**Subject:** George Hotel - HE Consultation Response

Further to our e-mails and ref. HE's structural concerns (copy attached) we respond to the further comment contained in the HE report as follows:

DEMOLITION PLAN
FIRST FLOOR

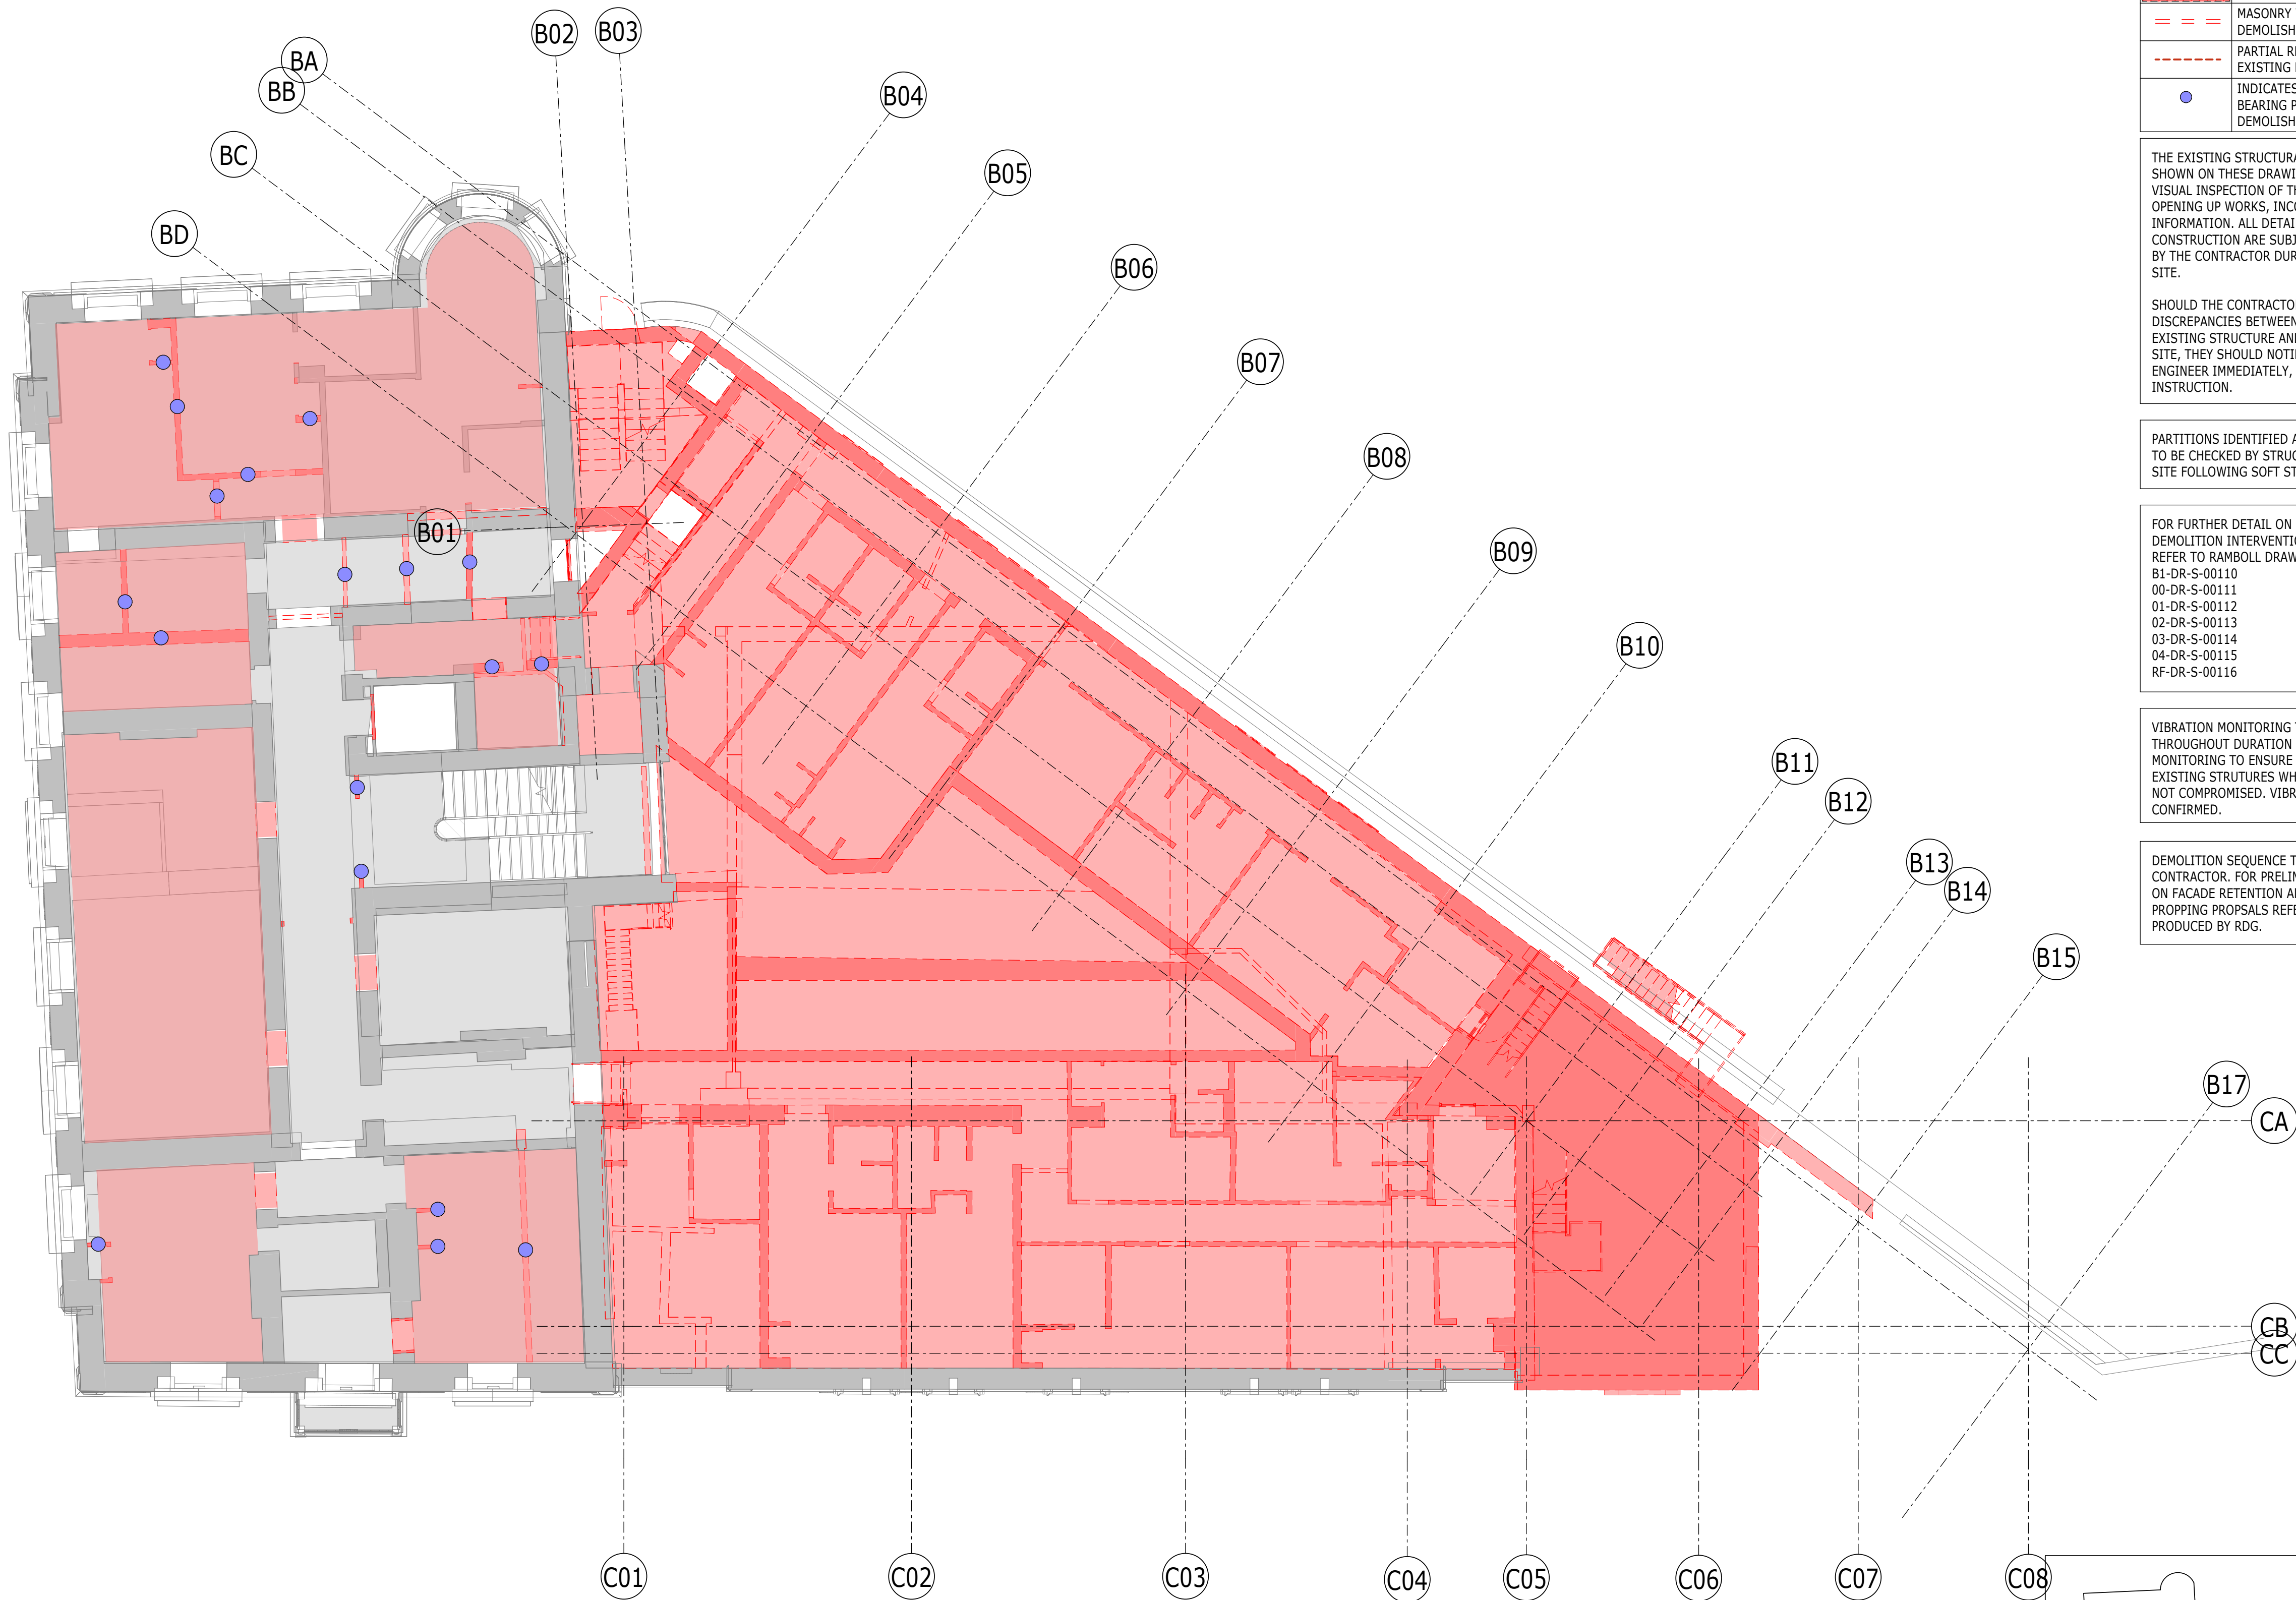
1. Floor replacement vs. strengthening. "We would wish to see the ground floor structure and the second floor structure above the first floor conference room retained and recommend a design solution is explored for these areas" *doc L01555367*

- Please see attached commentary by separate cover.
- 2. "Furthermore it is not clear if the existing joists are "failing" due to over-stressing or due to serviceability criteria (i.e. deflection)." Additional comment from NH dated 10.05.23

RCP Block A Level 02 Proposed  
1 : 100

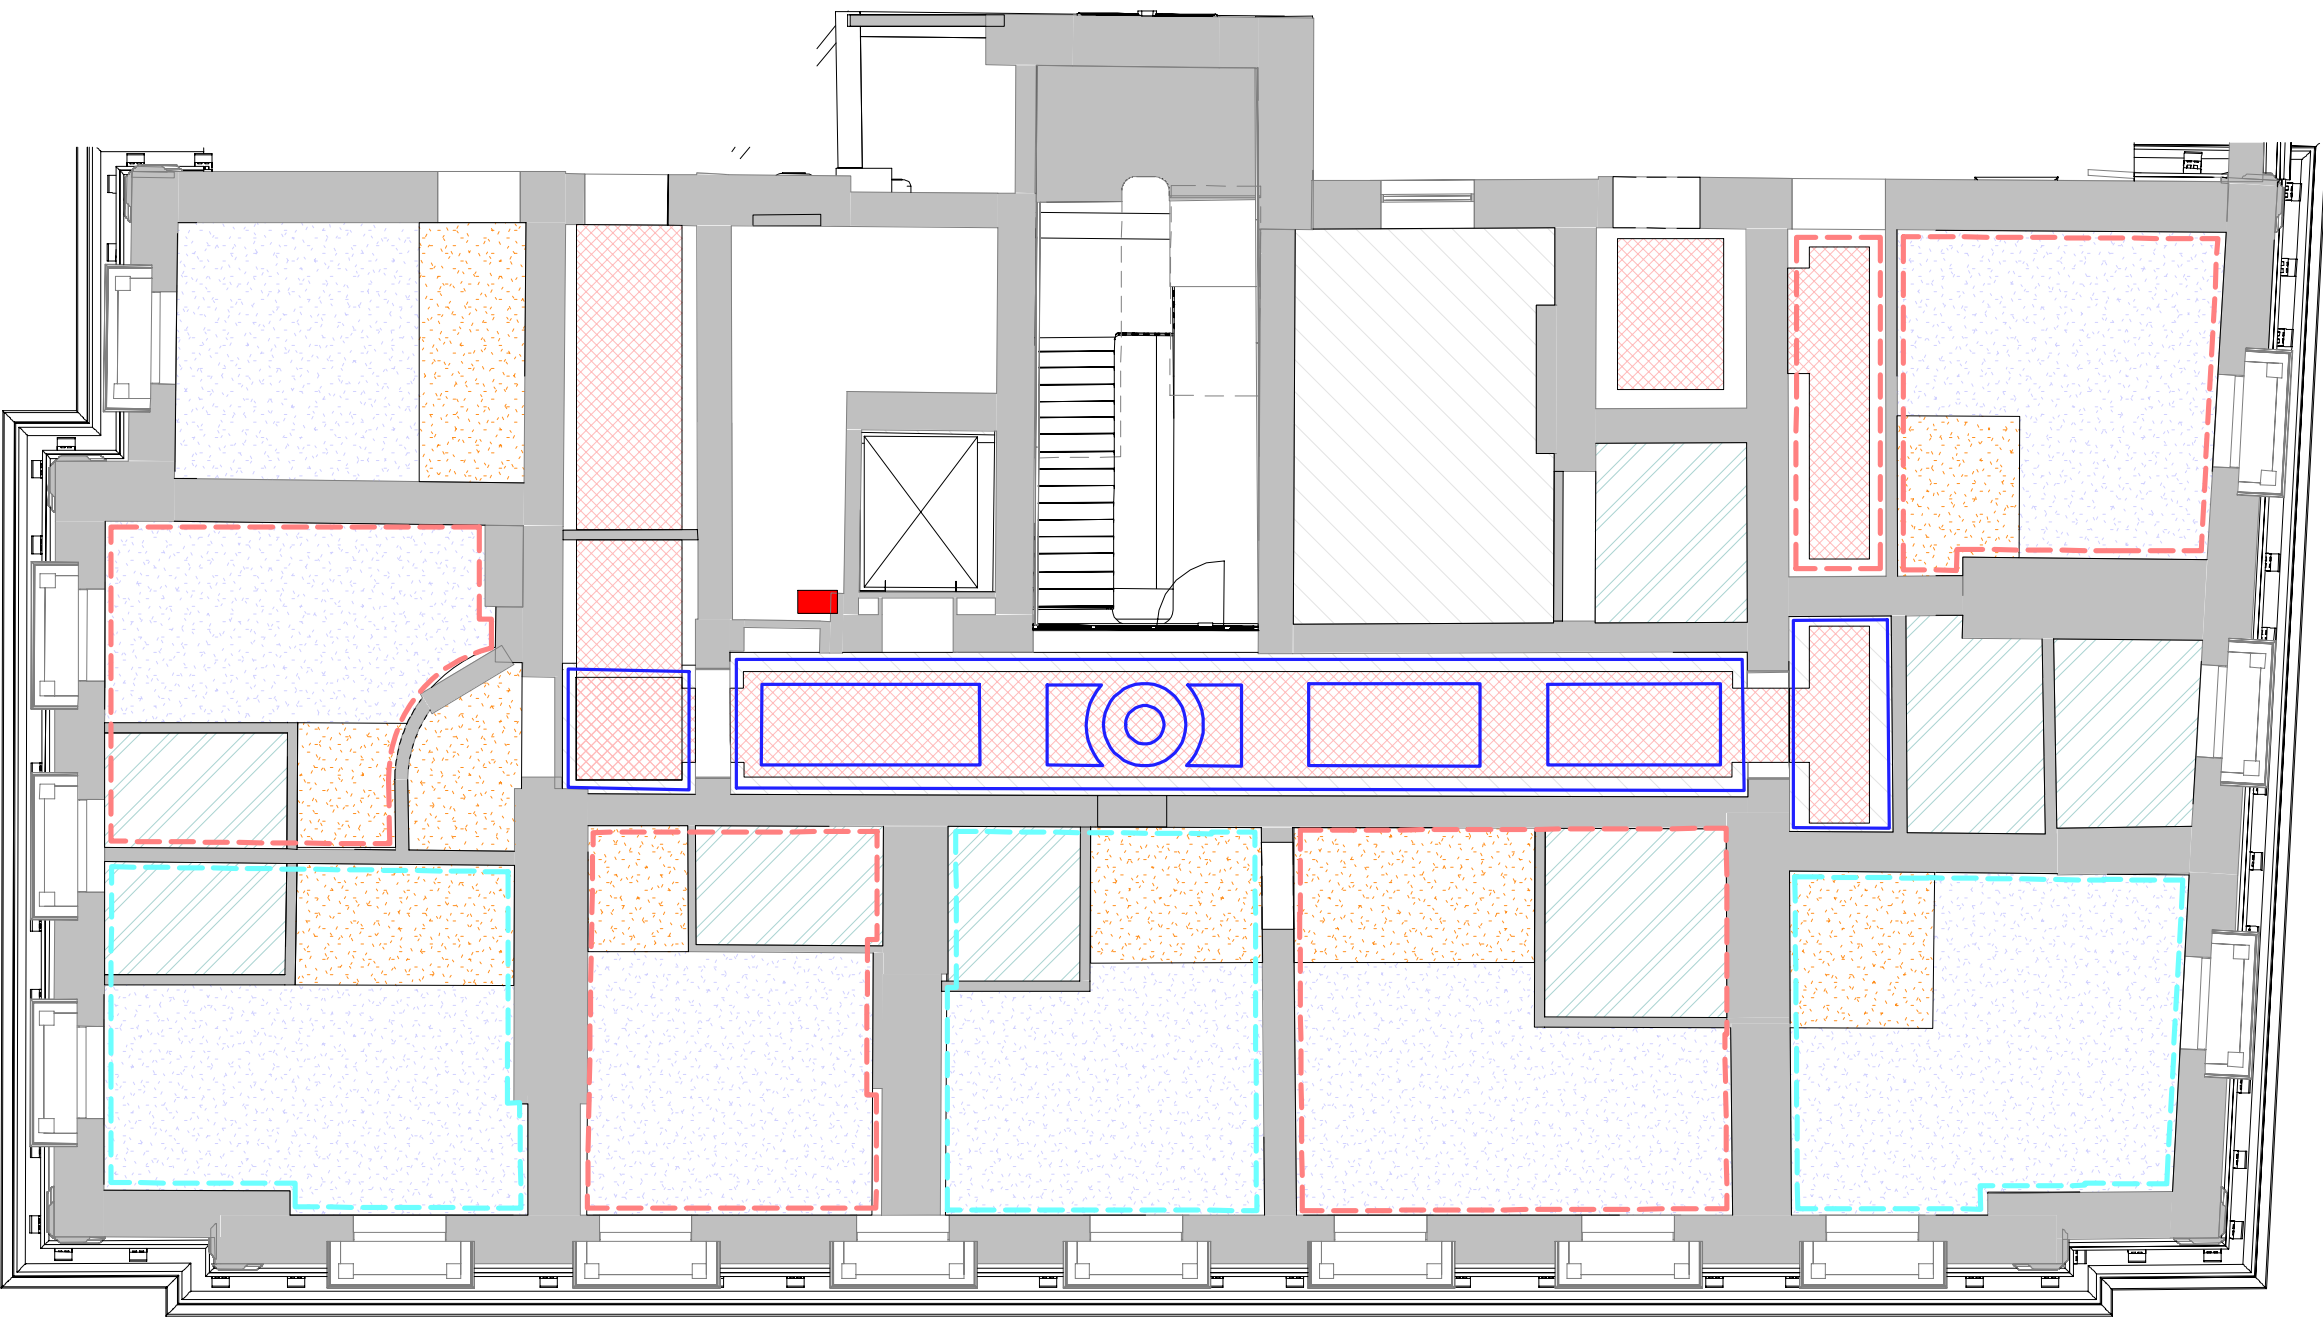
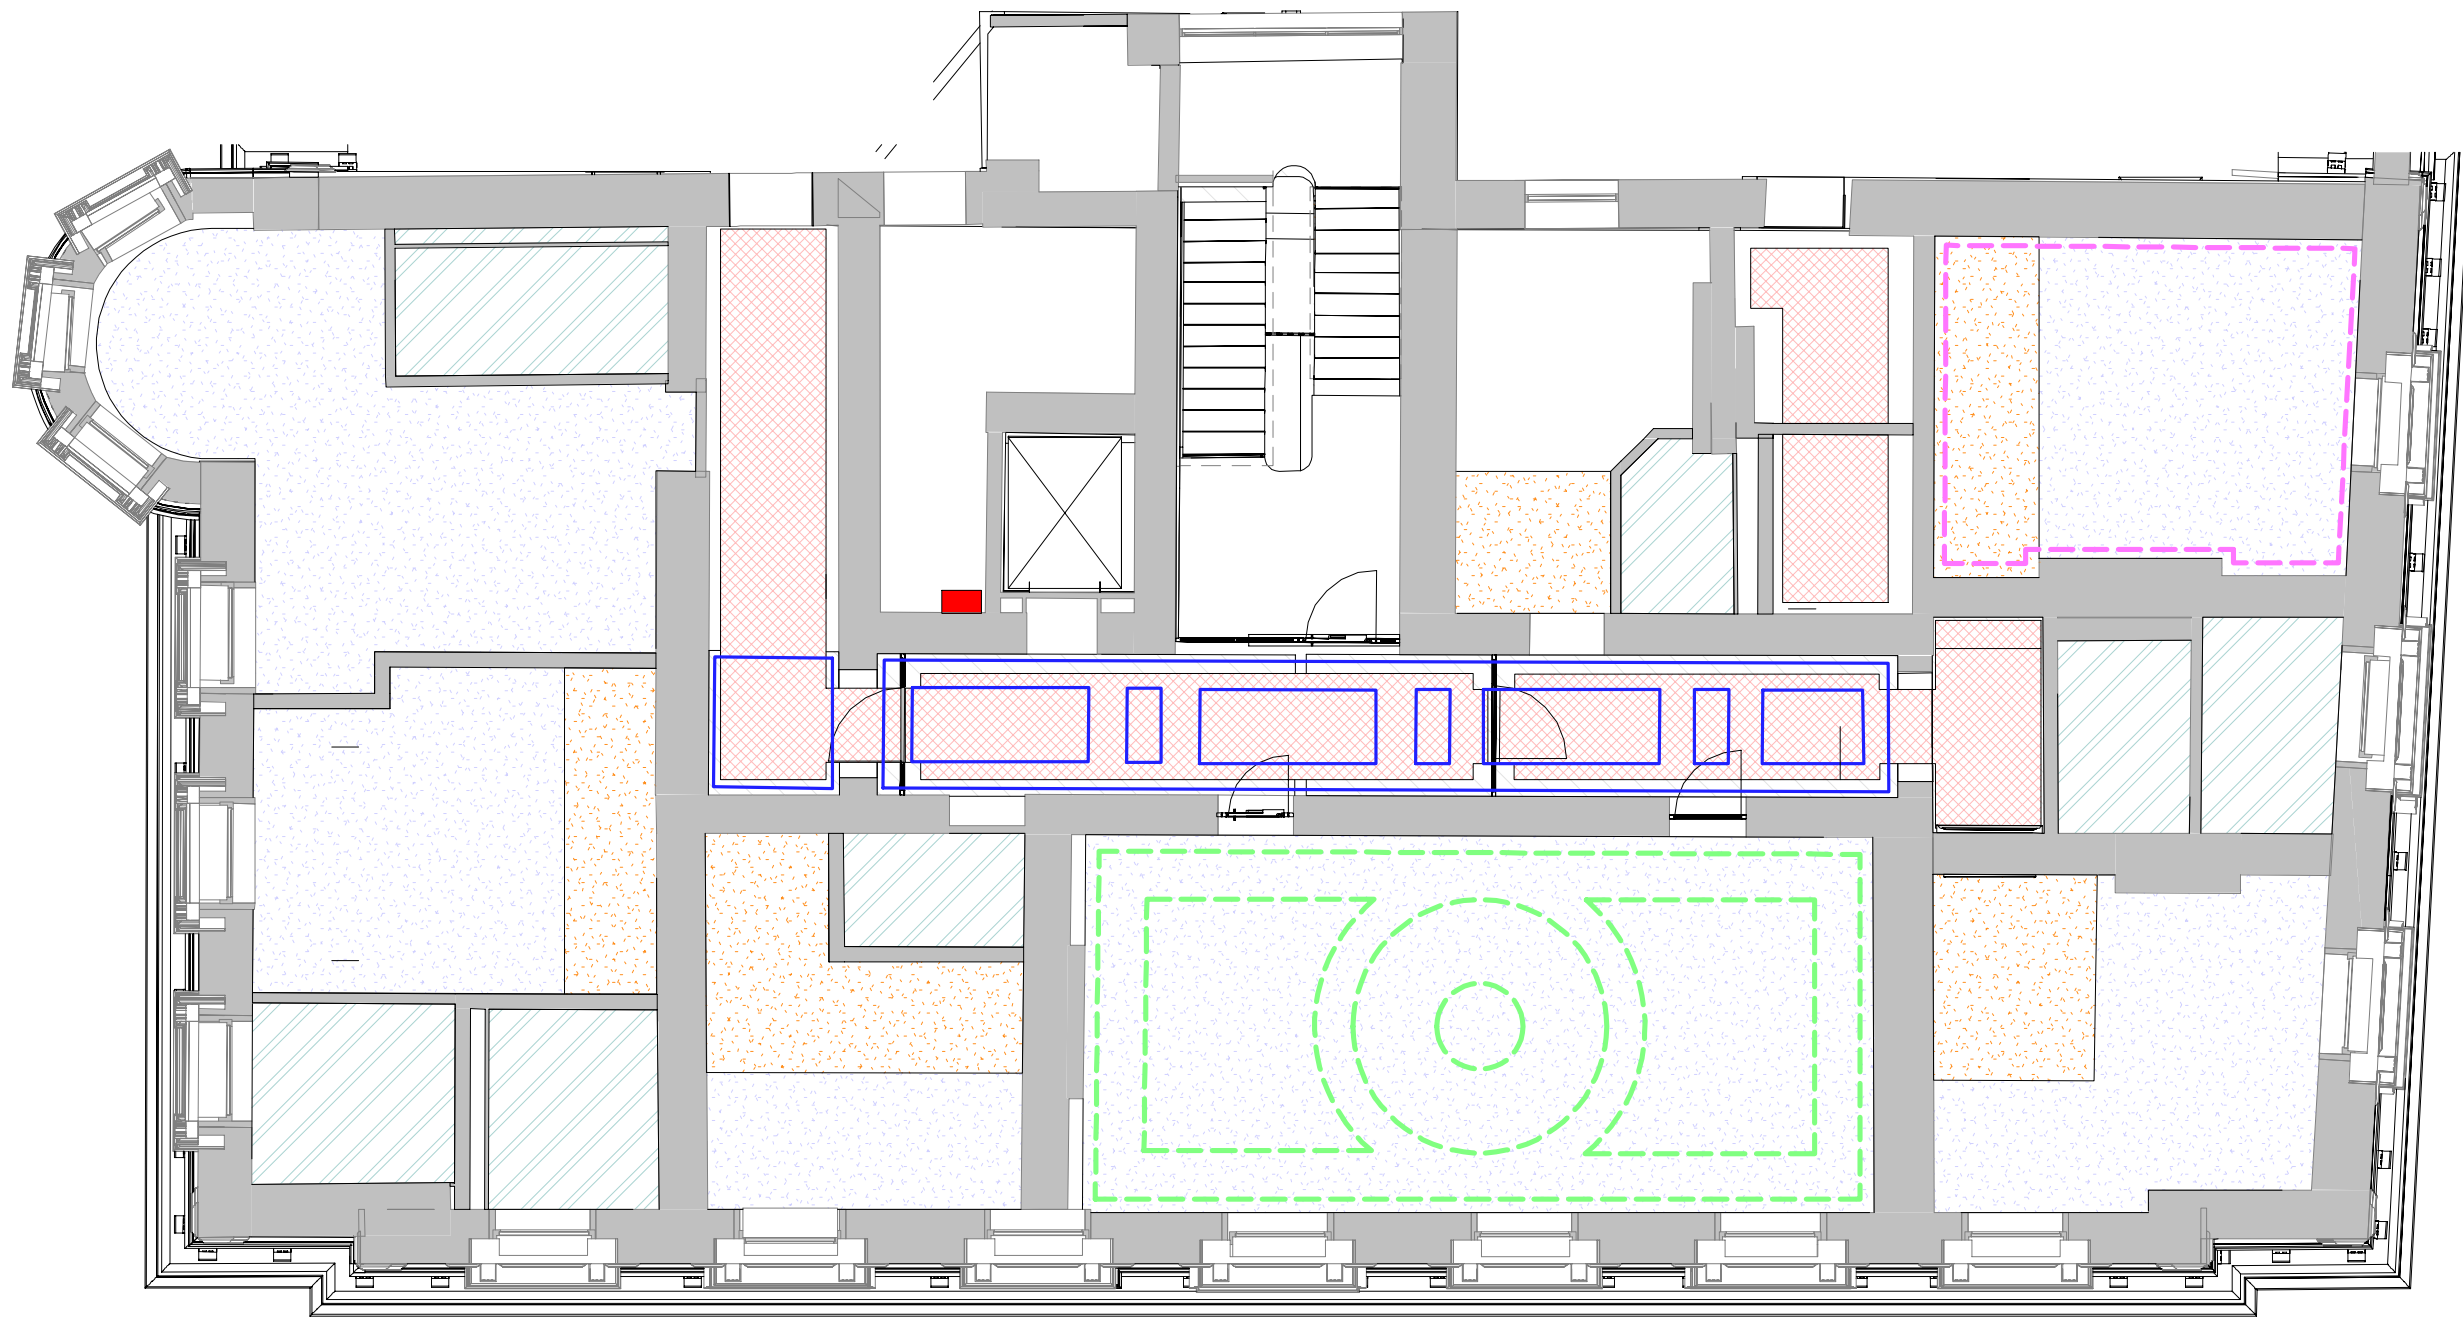
- Note timeframes and whether this is necessary. We suggest not as the viability assessment was carried out by a relevant professional company
- 7. "we are not satisfied that there is a convincing justification for the removal of *all* the floor structures in block A" doc L01555367

- Corridor floors and some room floors are *not* being replaced. See drawings.
  - Please see attached commentary by separate cover.
- 8. "The remaining less than substantial harm should be weighed against the public benefits of the scheme" doc L01555367
